Application number: 2025/92713	
What is the application for?:	Reserved matters application pursuant to outline permission 2023/92079 for erect
Address of the site or building:	Rear of, 23 to 43, Moor Lane, Gomersal, Cleckheaton, BD19 4LF
Postcode:	LS10 1NB

User comments

Tree Protection Plan to BS5837:2012 at:
Moor Lane, Gomersal

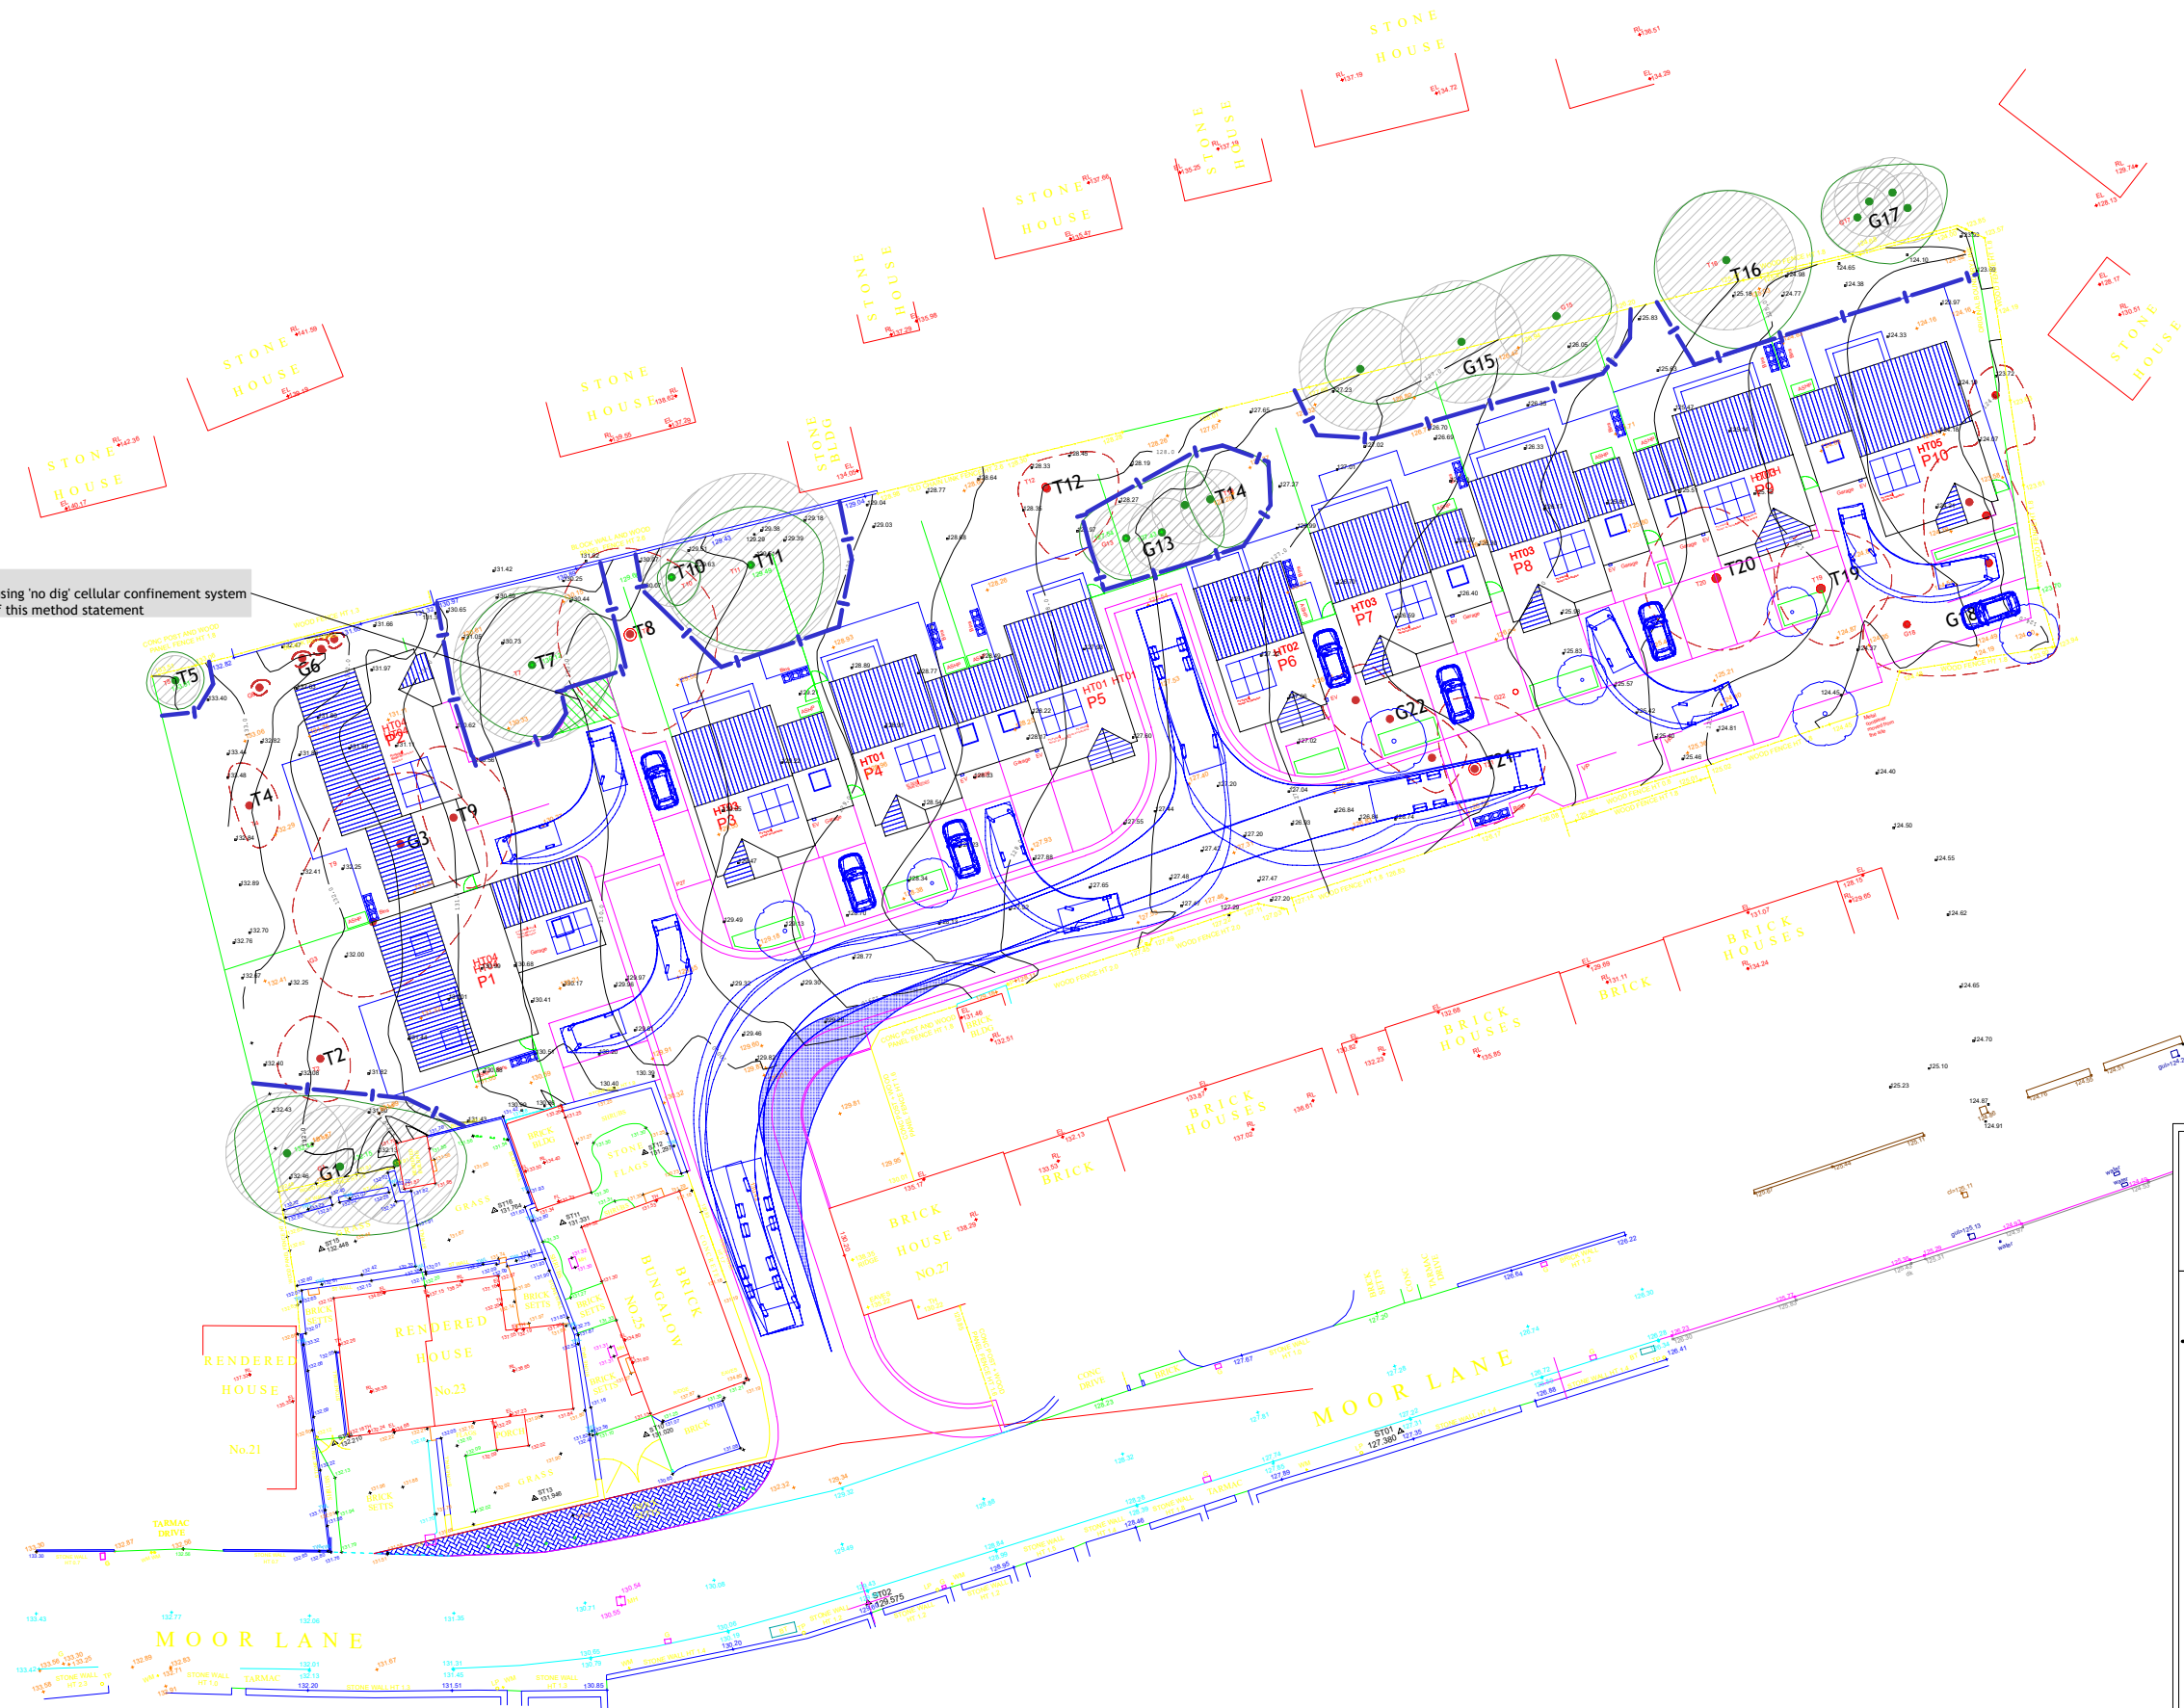
Furthermore, the majority of the retained trees will fall within the gardens of the private dwellings and therefore cannot be secured. As such this should be recorded as a loss, or at the very least a reduction in condition to represent the fact the trees cannot be secured but will be retained.
